Site Development Plan Comments V2.pdf Markup Summary

[1] S-1 Site Development Plan (2)

[2] S-2 Parking Plan (5)

BASIS OF BEARINGS:

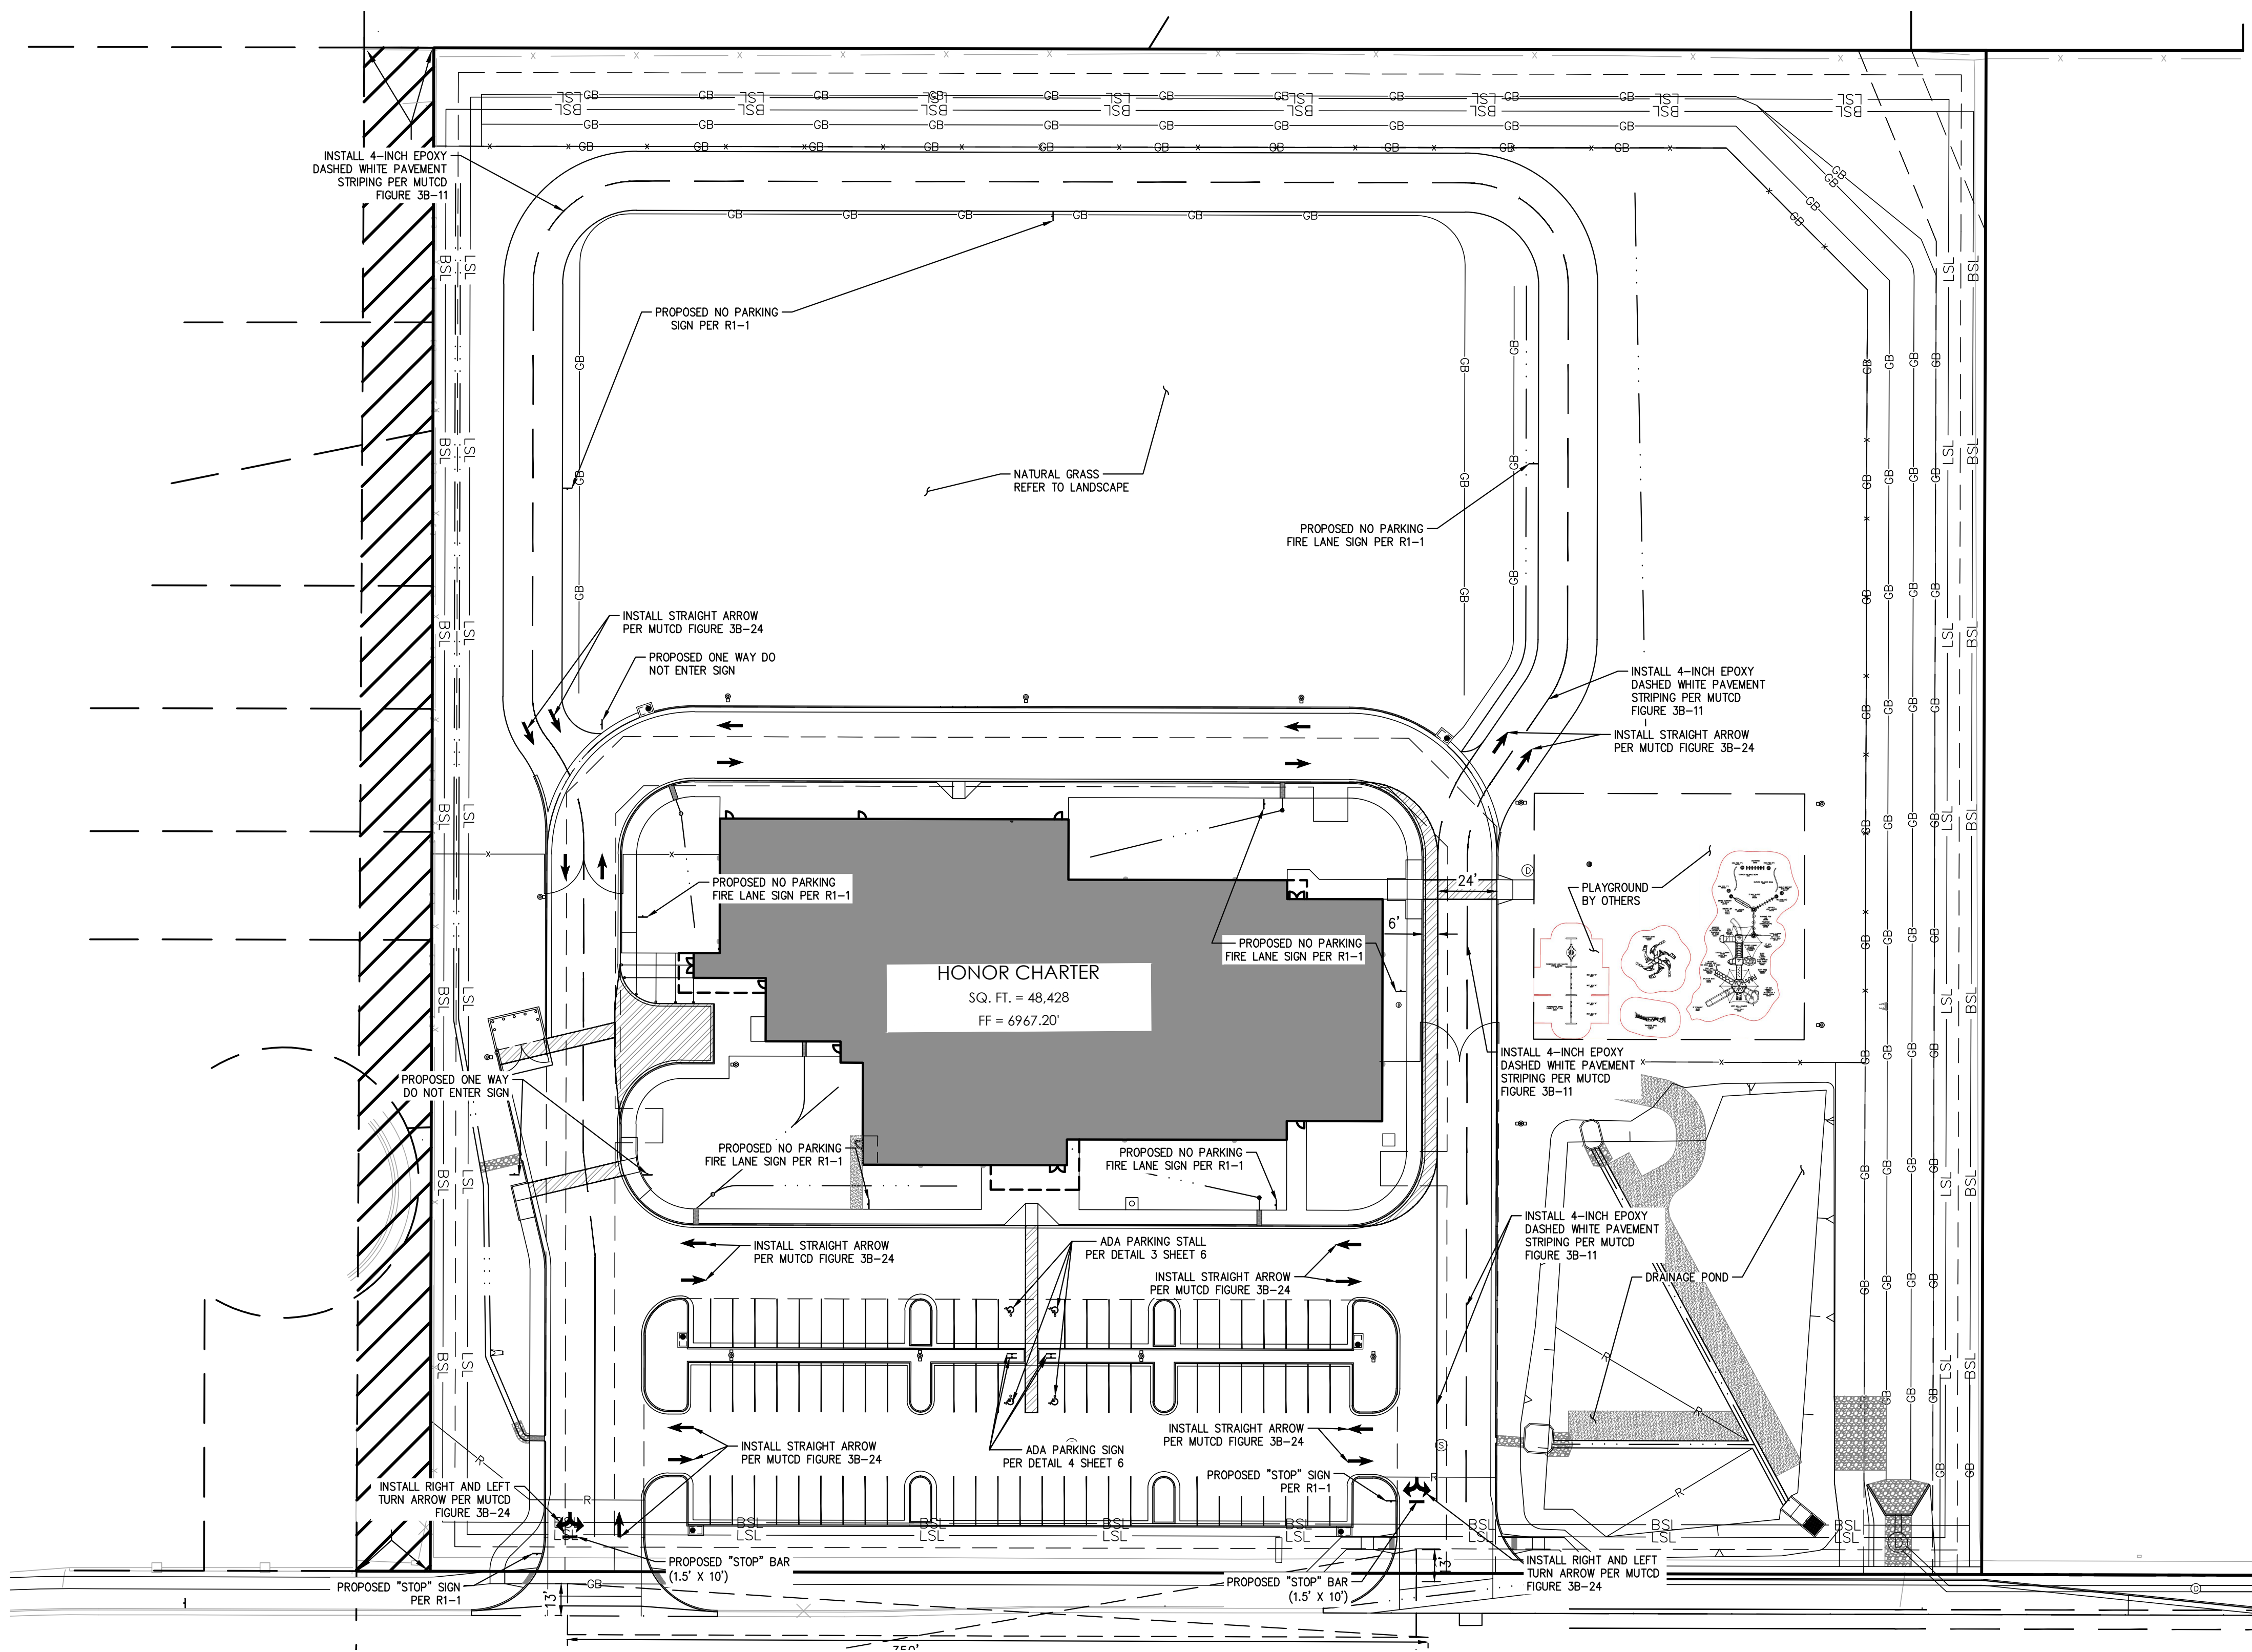
provide the actual setback numbers and 15' buffer at north and west property line required and line.

buffer required at northern and western property lines. PUD Condition of approval

The building setbacks along the north and west have been set to 15'. added screen fence on the north side, and callout on the west side

Dimensions have been added to the site development plan for the buffer/setback distance on each property line.

TAIT Response:
A solid 6' tall wood picket fence will be provided at the northern and western property lines where not already screened by adjacent private fences.
